May 14, 2021

**Re: Suncadia Phase 2 Division 6 - Nelson Ridge
Engineering Plan Submittal**

On behalf of New Suncadia, ESM Consulting Engineers, LLC is submitting this letter in response to your review letter we received on April 28, 2021 together with the revised construction plans. In an effort to provide concise and direct responses, we have copied the review comments below in *italics* and our responses are in **bold**.

JOB NO.:	998-812-020
DWG. NAME:	WS-02
DESIGNED BY:	LGB
DRAWN BY:	JH
CHECKED BY:	
DATE:	05/13/2021
DATE OF PRINT:	
WS-02	
16 OF 29 SHEETS

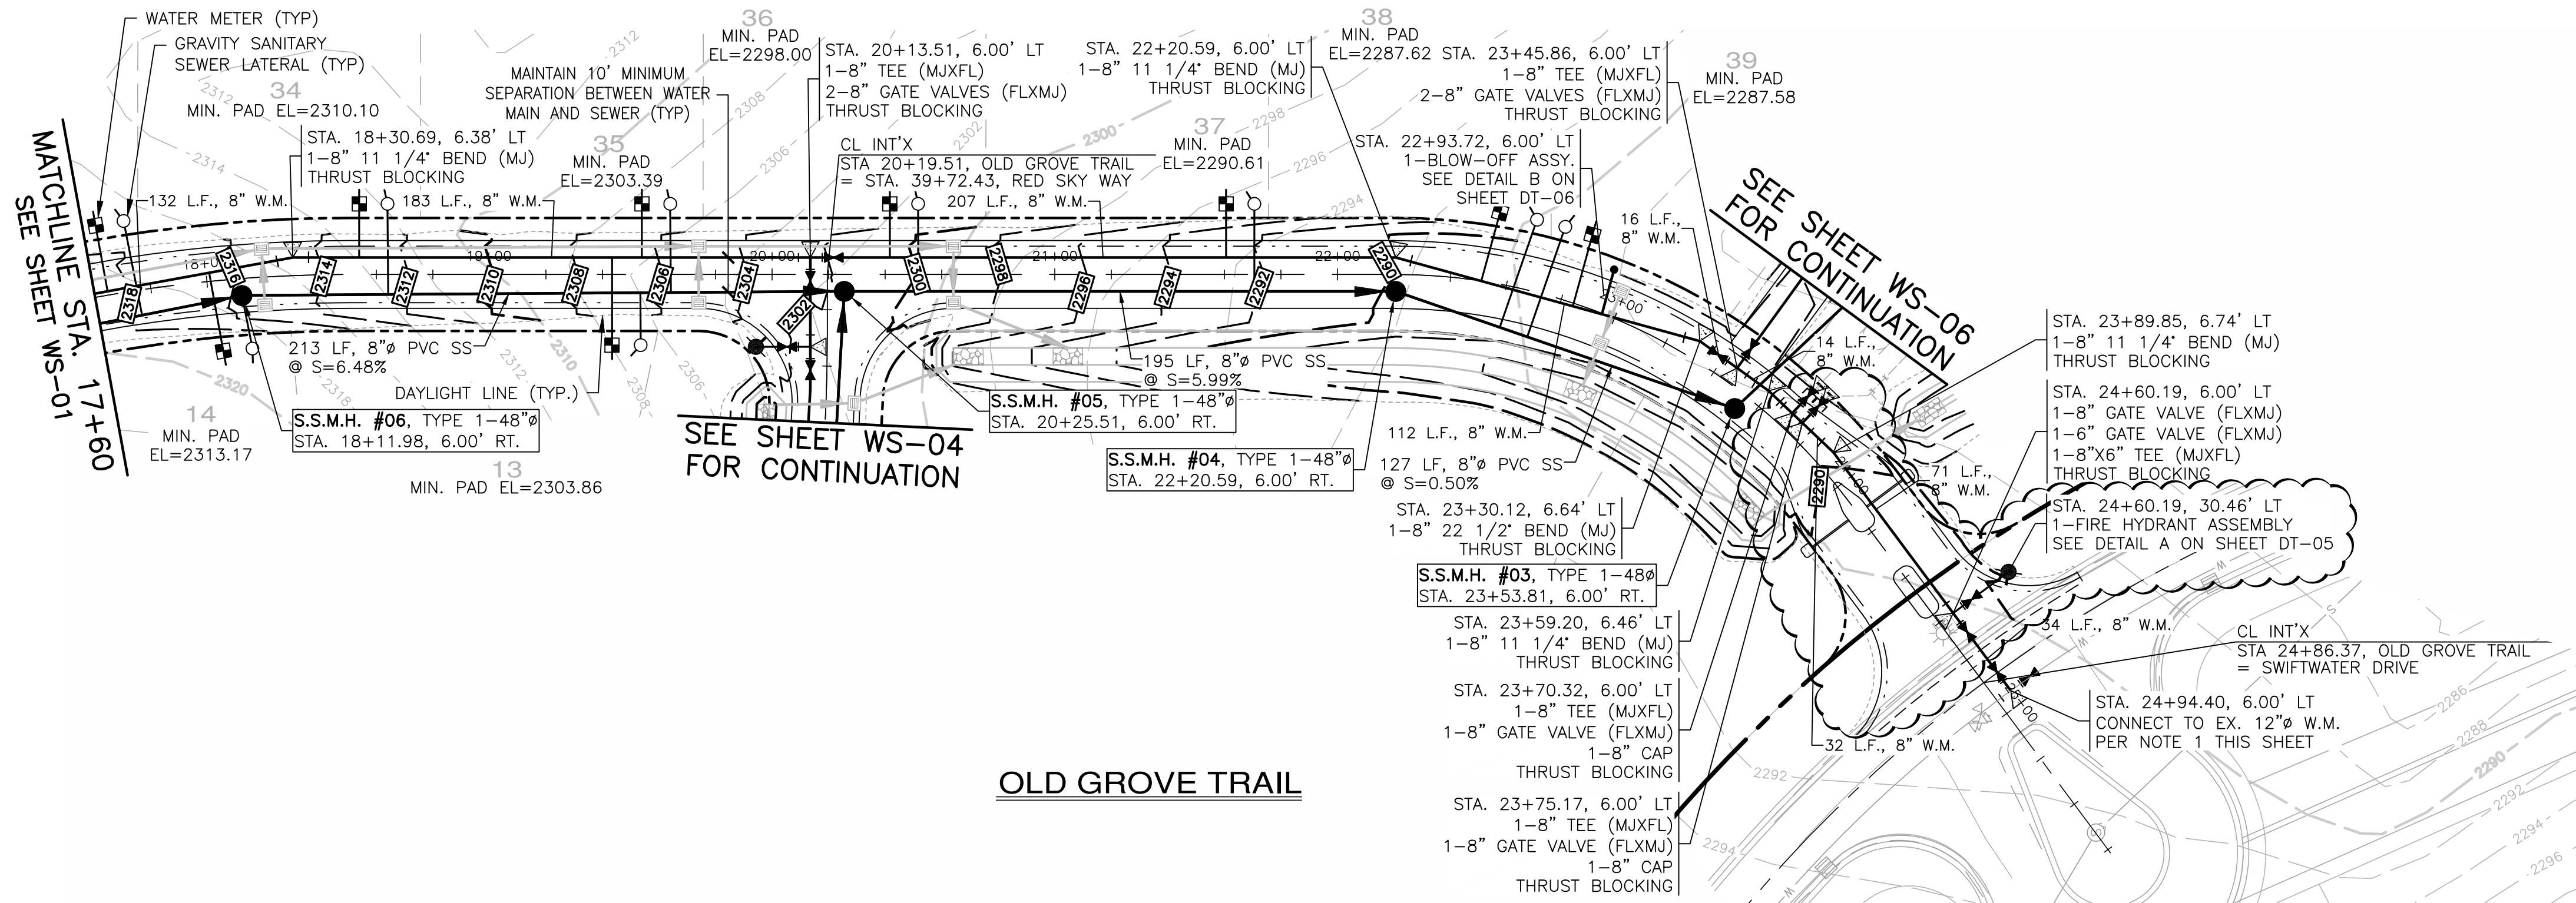
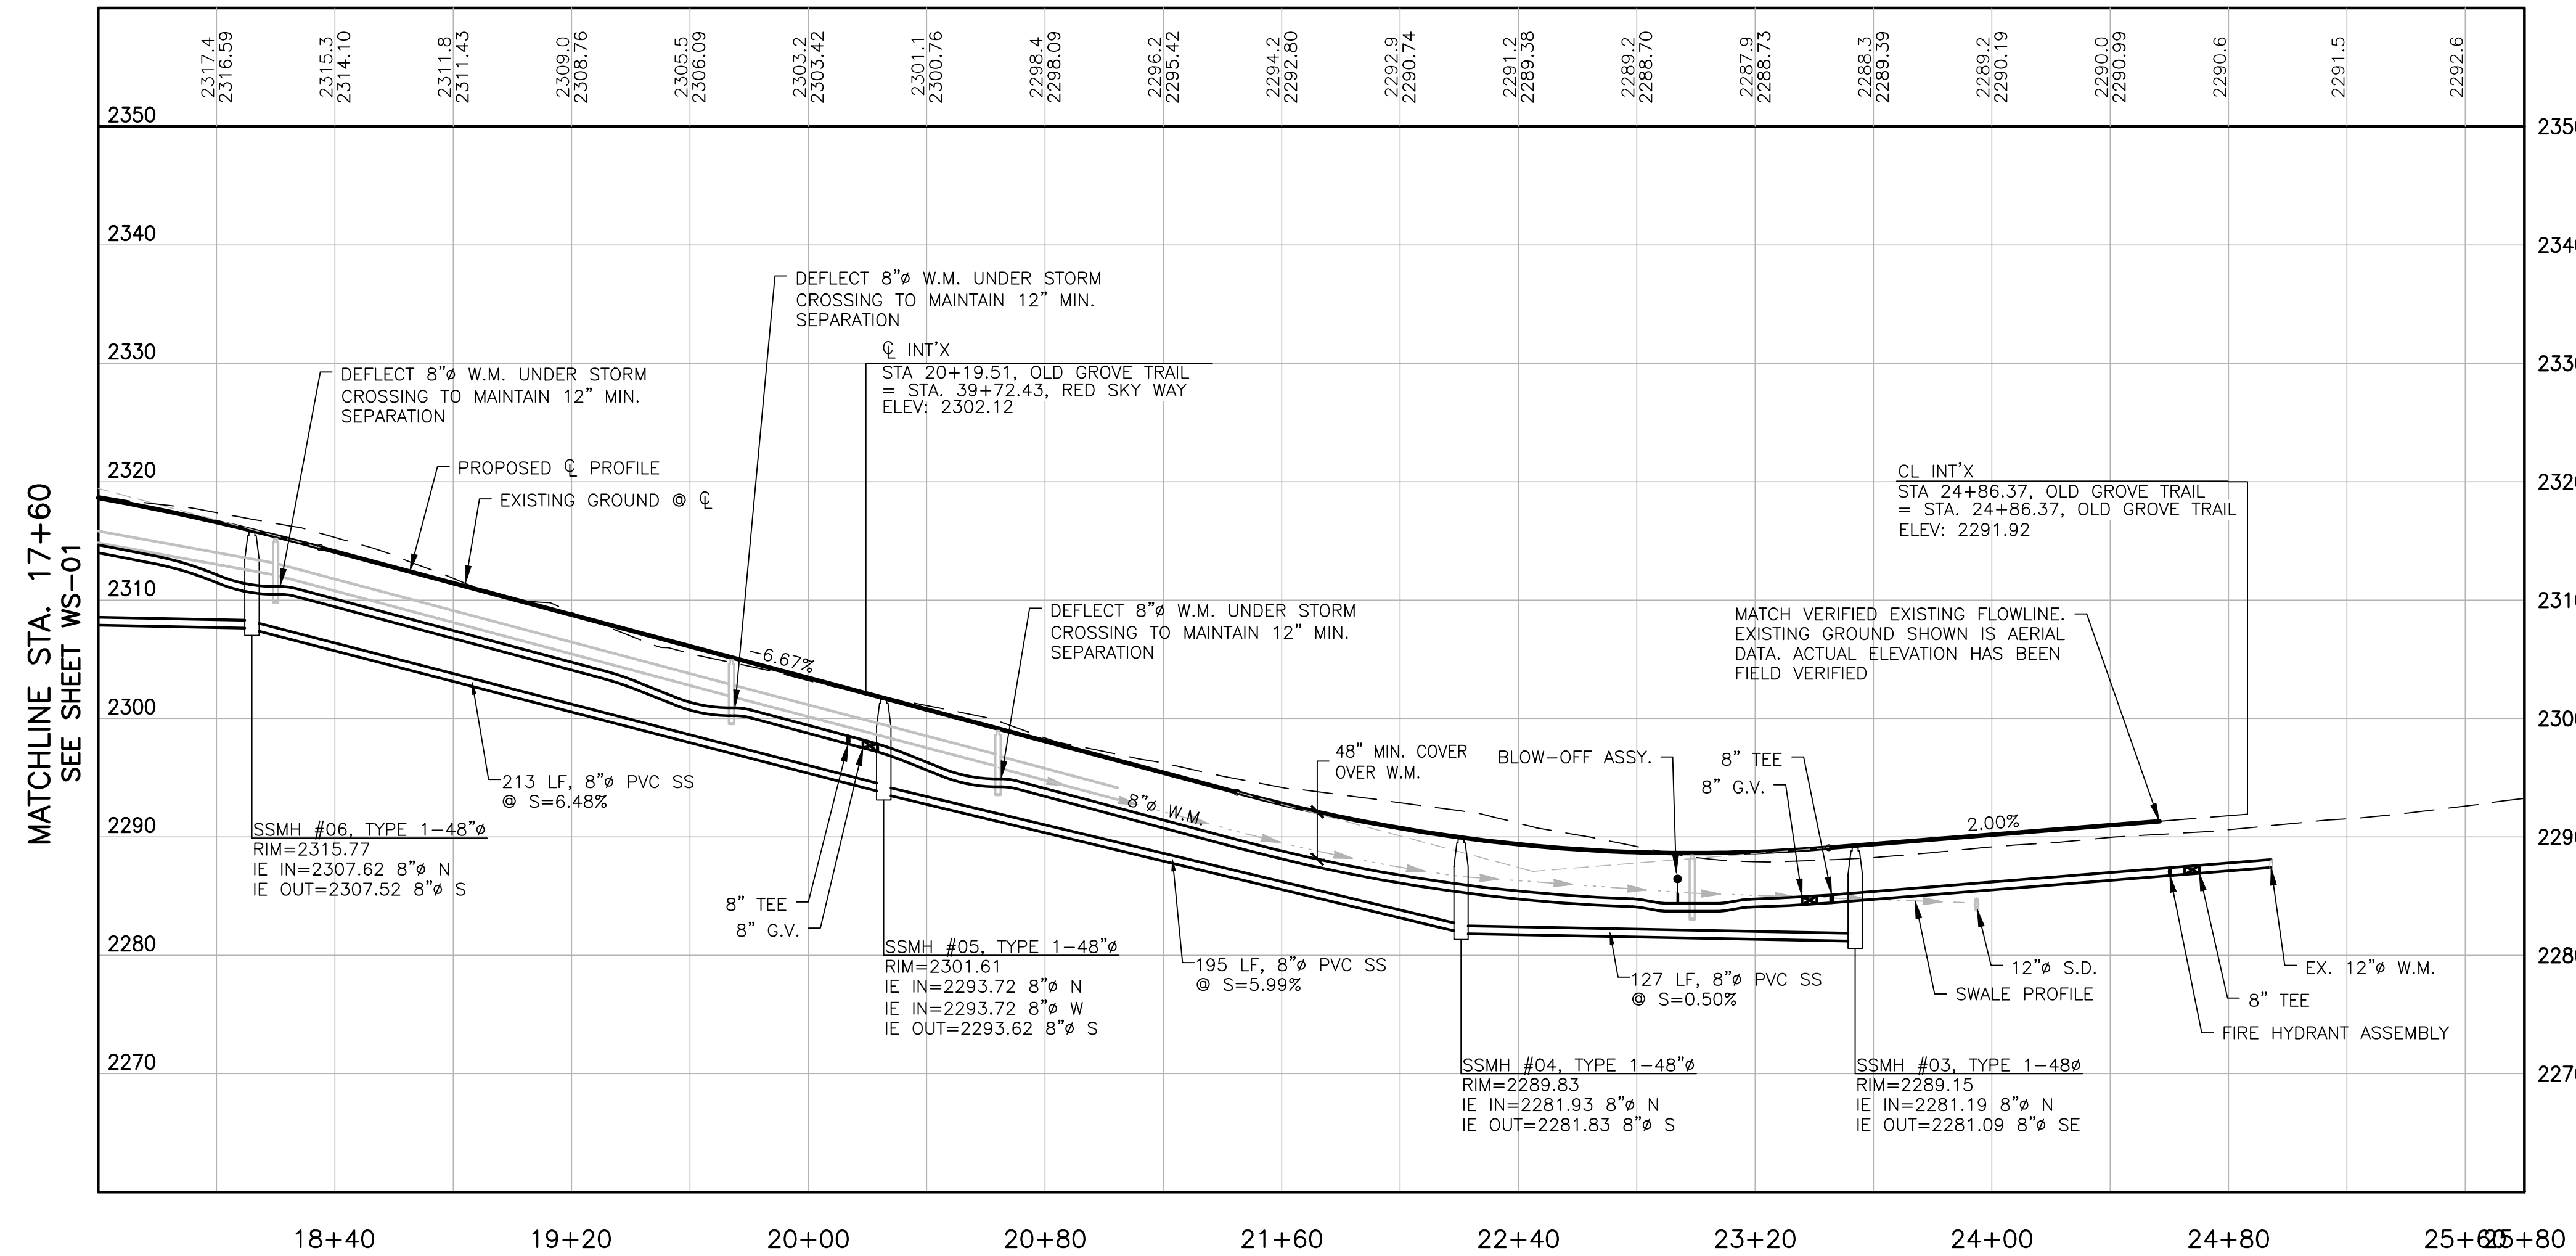
- 1. Within the plan set a number of pipes aren't labeled. Please be sure to label all pipes on sheets RD-01, RD-02, RD-05, and WS-02.*

The pipes have been labeled as requested.
